## Advice on Response to Submission – State Significant Development

**Proposal:** Taronga Zoo Sky Safari

**Major Project reference:** SSD-46807958

Figure 26 Top Station Location Plan

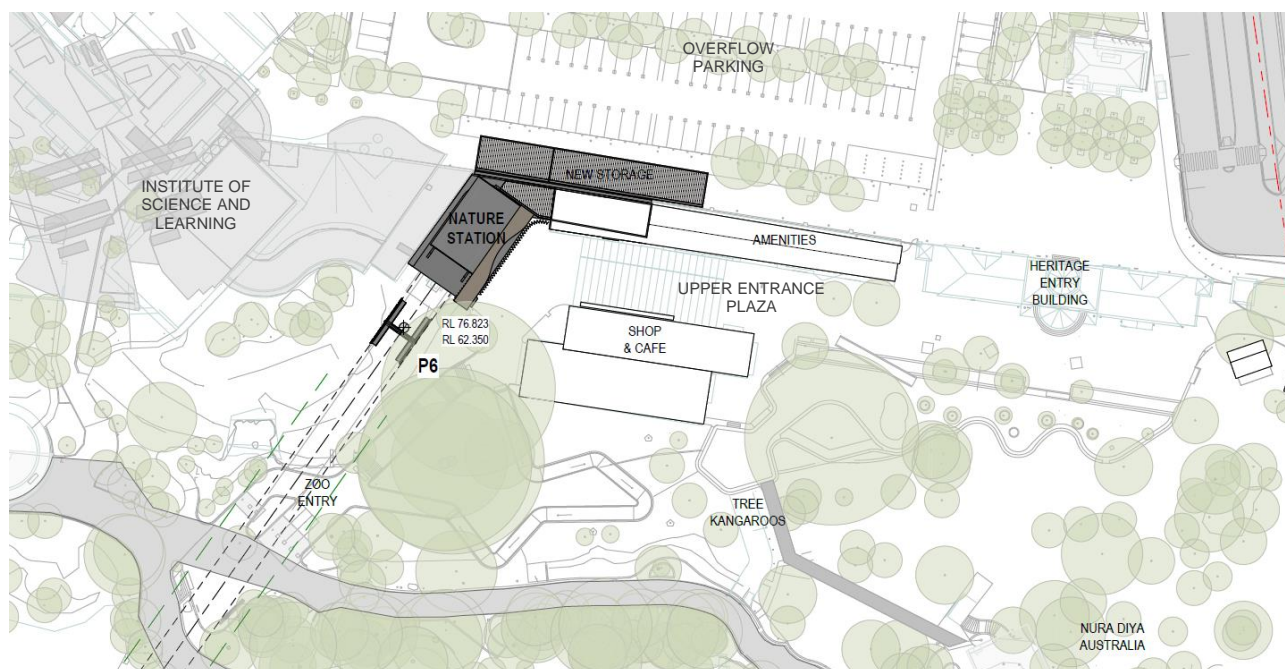
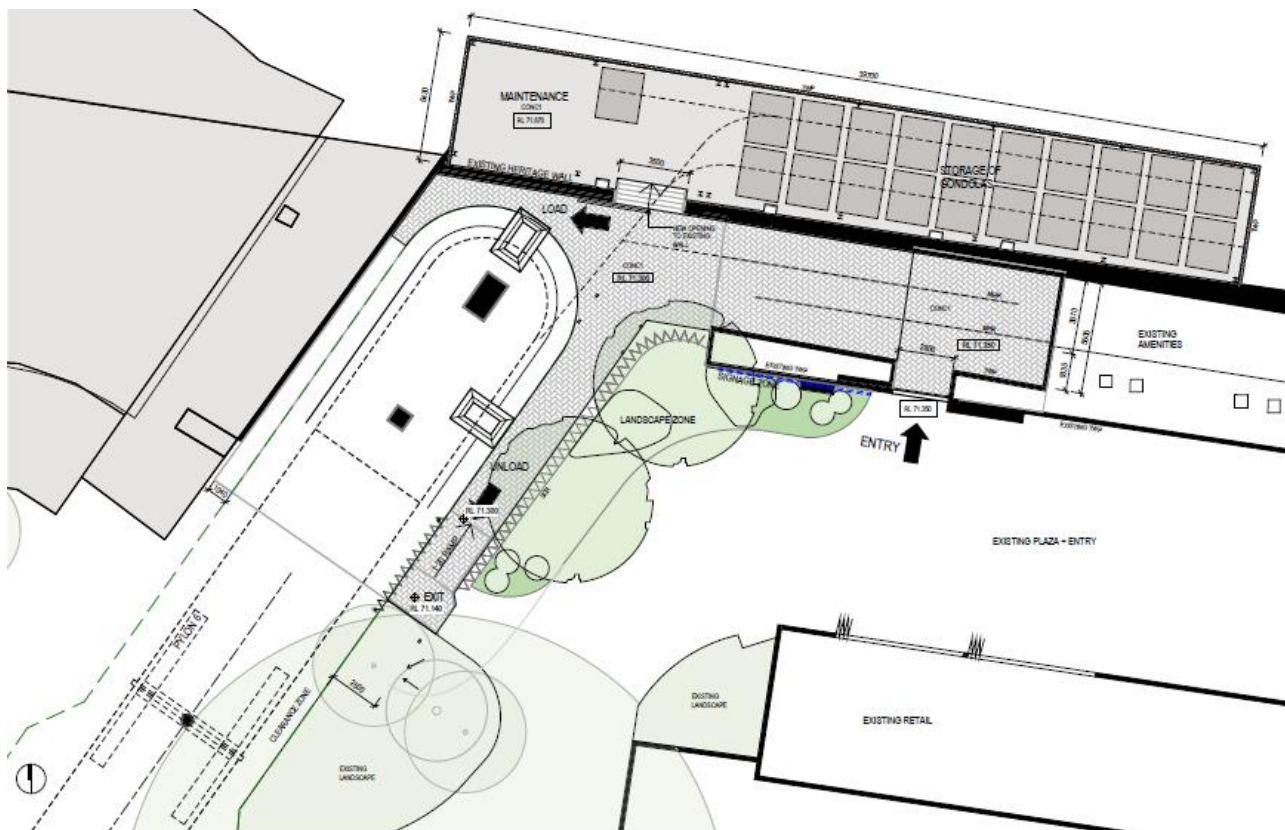
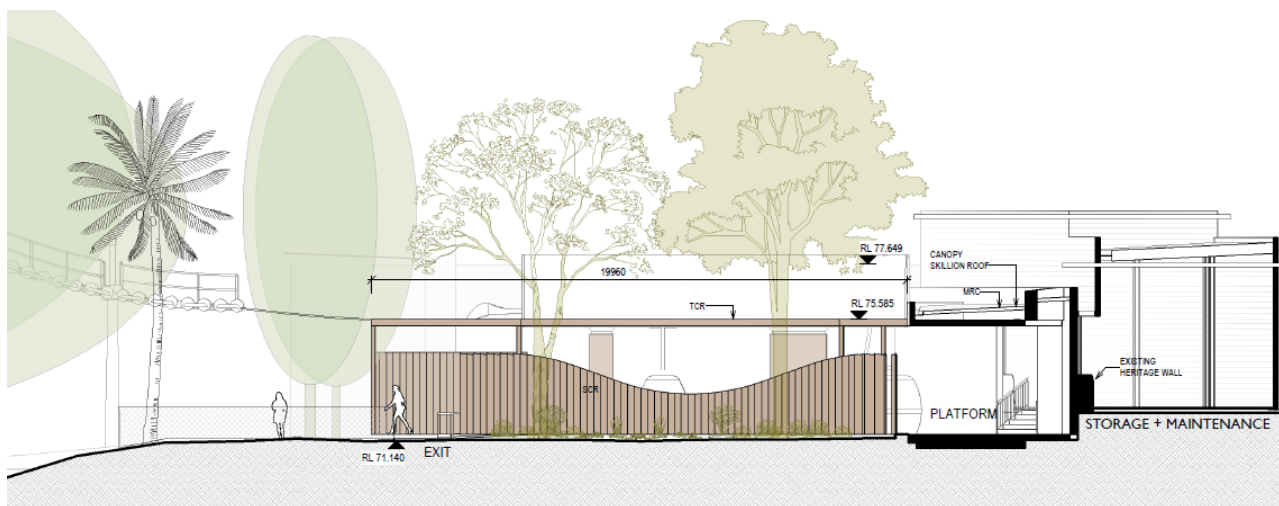
- a. It is noted that the MSB facade treatment has been amended to interpret the line of the adjacent sandstone wall and to provide an enhanced response to its context. The amended facade treatment is supported.

- b. The design report states that the size of the MSB has been minimised according to its functional requirements. We recommend that further ways to reduce the size of the MSB be considered where possible, including potential shared use of the covered queueing area for gondola storage.

- c. It is recommended that fixings into the sandstone wall be avoided. The MSB should be designed and built to be structurally independent of the stone wall, and so that it could be removed in the future without damage to the wall.

- d. The junction of the MSB walls to the stone wall should be detailed to incorporate a visual separation device to allow the stone wall to remain legible as a separate structure.

- e. The MSB structure (including steel columns and footings) is to be designed and built to avoid physical impacts to the stone wall and its footings.

Figure 29 Lower Station Location Plan

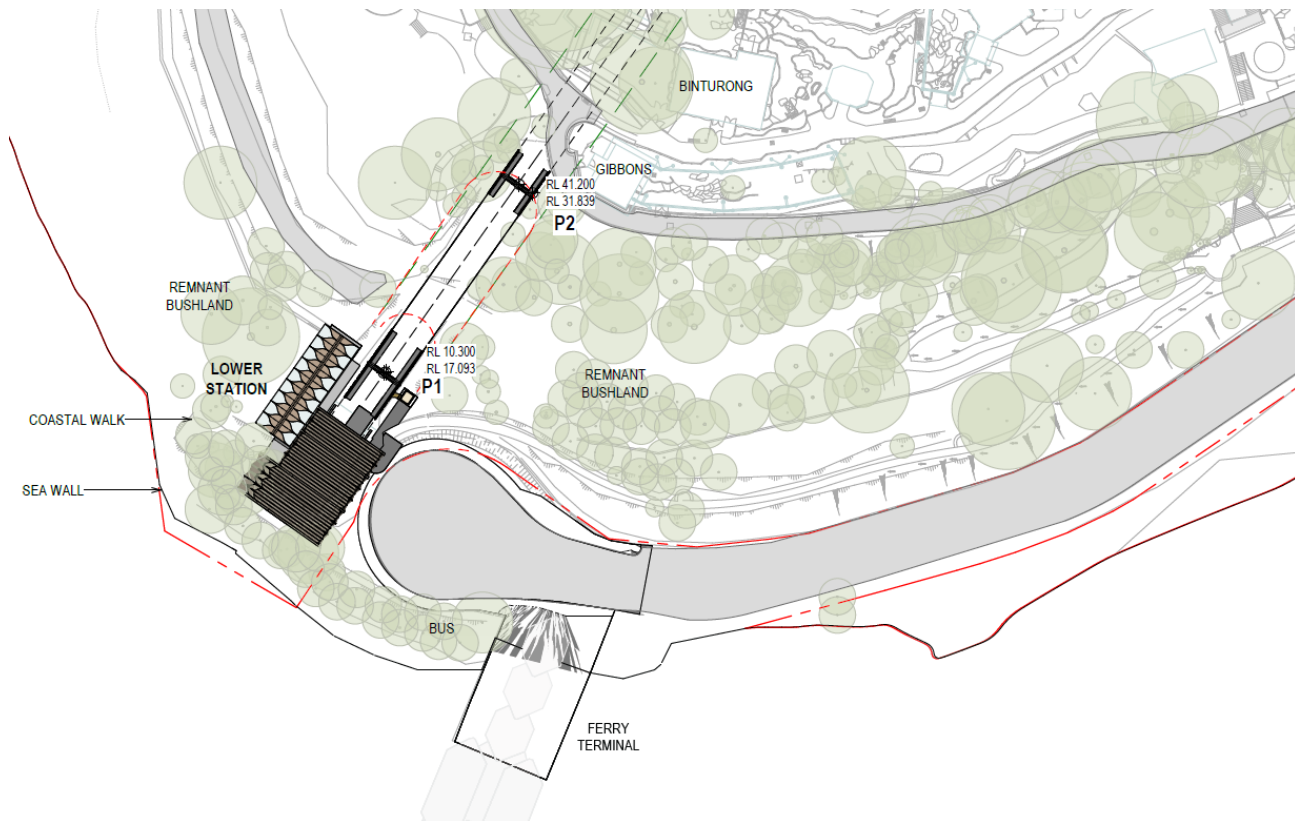
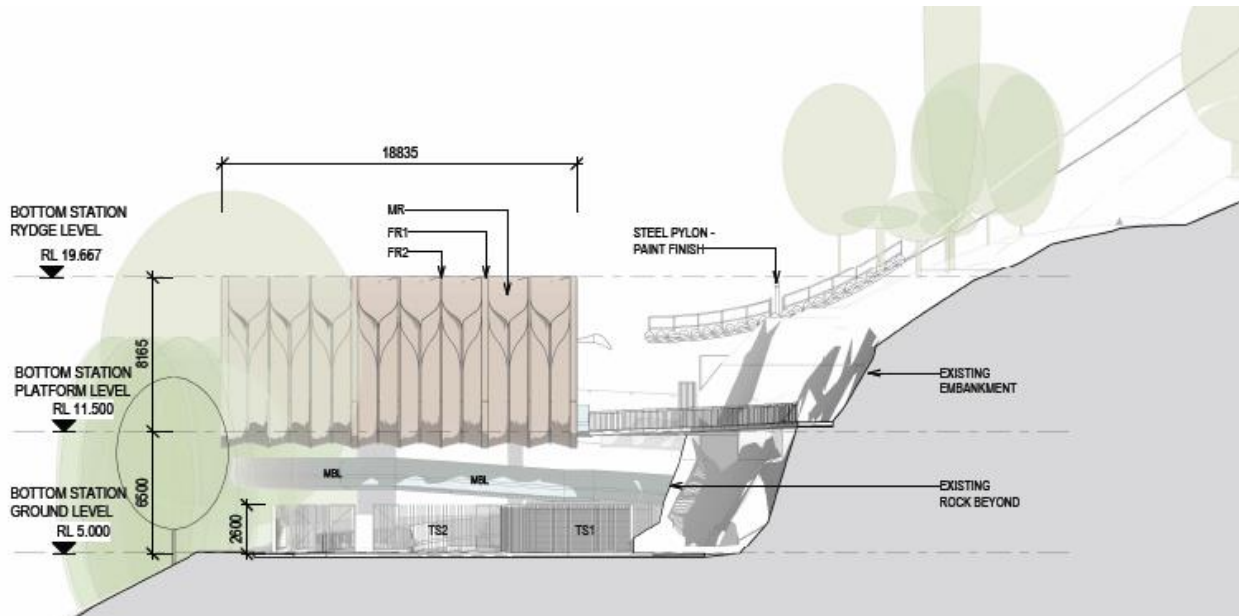
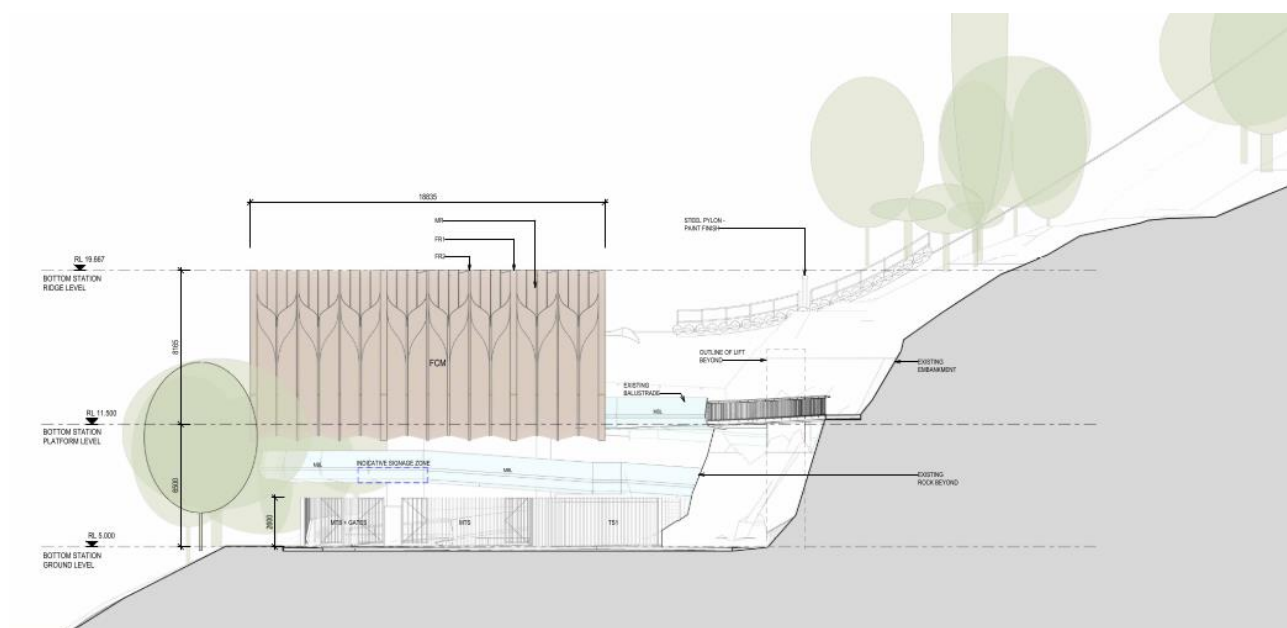
- a. It is recommended that the extent of sandstone excavation around the bottom station be minimised, and that excavation be undertaken using methodologies that would avoid impacts to surrounding vegetation.
- b. It is understood that a portion of the sandstone boundary wall is to be demolished on the western side of the bottom station. Measures should be taken to protect the retained section of wall from damage and methodologies for sandstone excavation should be adopted to ensure that the retained part of the wall remains stable and intact.
- c. The enclosing envelope of the bottom station has substantially increased in size as part of the modified design making the structure more prominent from the east and south-east. We recommend that consideration be given to reducing the perceived bulk and prominence of the bottom station.
